Subject: RE: Planning Consultation on: BR/292/20/PL

With regard to the noise impact assessment (Butlin's Bognor Regis Temporary Venue Noise Impact Assessment, 002, November 2020 by Max Fordham LLP) Environmental Health would make the following comments:

Application No: BR/292/20/PL
Registered: 7th December 2020
Site Address: Butlins Upper Bognor Road Bognor Regis PO21 1JJ
Grid Reference: 494416 99407
Description of Works: Erection of temporary buildings to accommodate performance stage and seating for a period of up to 3 years. This site is in CIL Zone 4 (Zero Rated) as other development.

Figure 1: A site plan showing the site boundary of the Butlin's site in red, as well as the locations of the measurement positions, nearest noise sensitive receiver and the approximate location of the proposed venue. Imagery courtesy of Google.

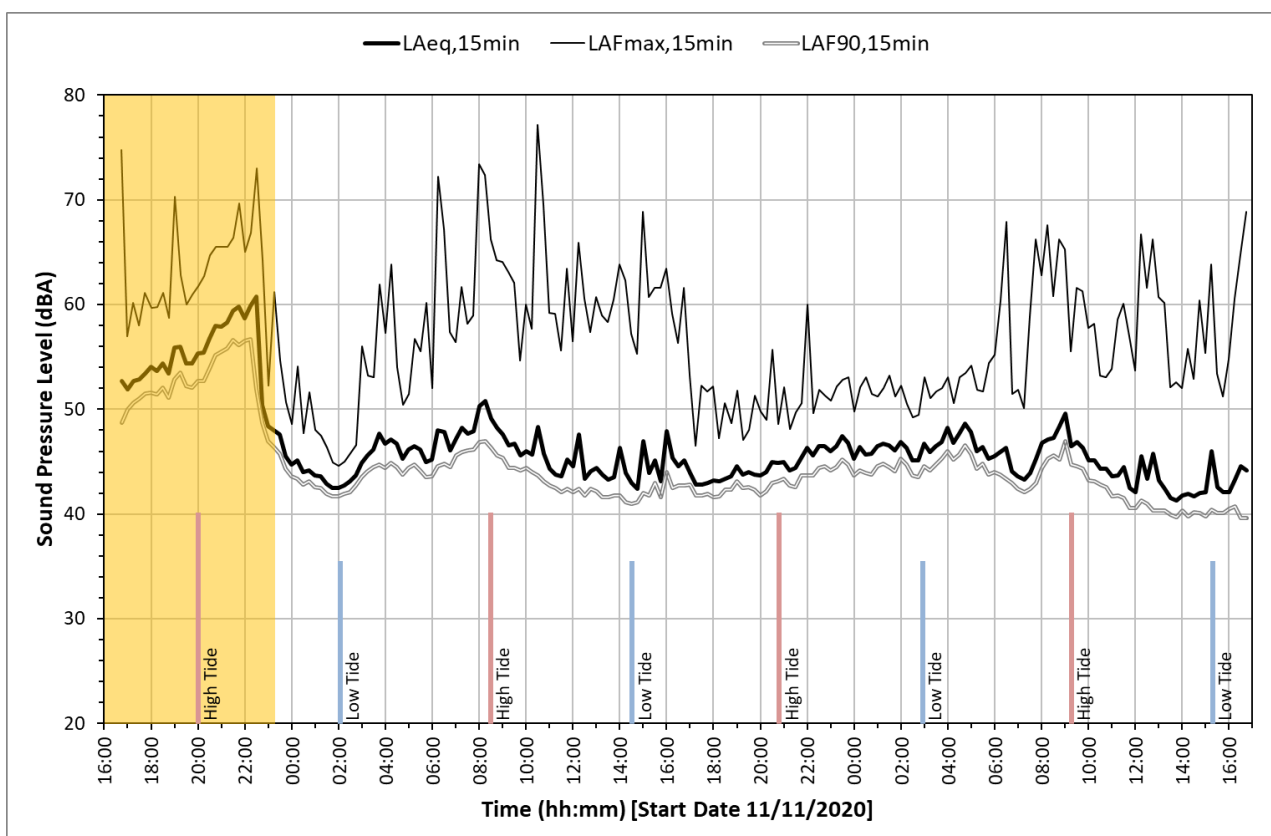
3. With regard to Section 3.1, Environmental Health has concerns that the survey location chosen by the applicant may not be entirely representative of the nearest noise sensitive residents. There is a block of flats on the corner of The Esplanade and Gloucester Road called Compass Point. These flats would be directly in the line of sight of the new venue, across the Gloucester Road Car Park. The survey location for the acoustic report is located slightly further north on Gloucester Road and it would appear that some shielding from the Atlantic Bay Apartments may occur (in terms of noise). Please could the applicant confirm whether or not these factors were taken into account during the noise survey, and provide any justification necessary?
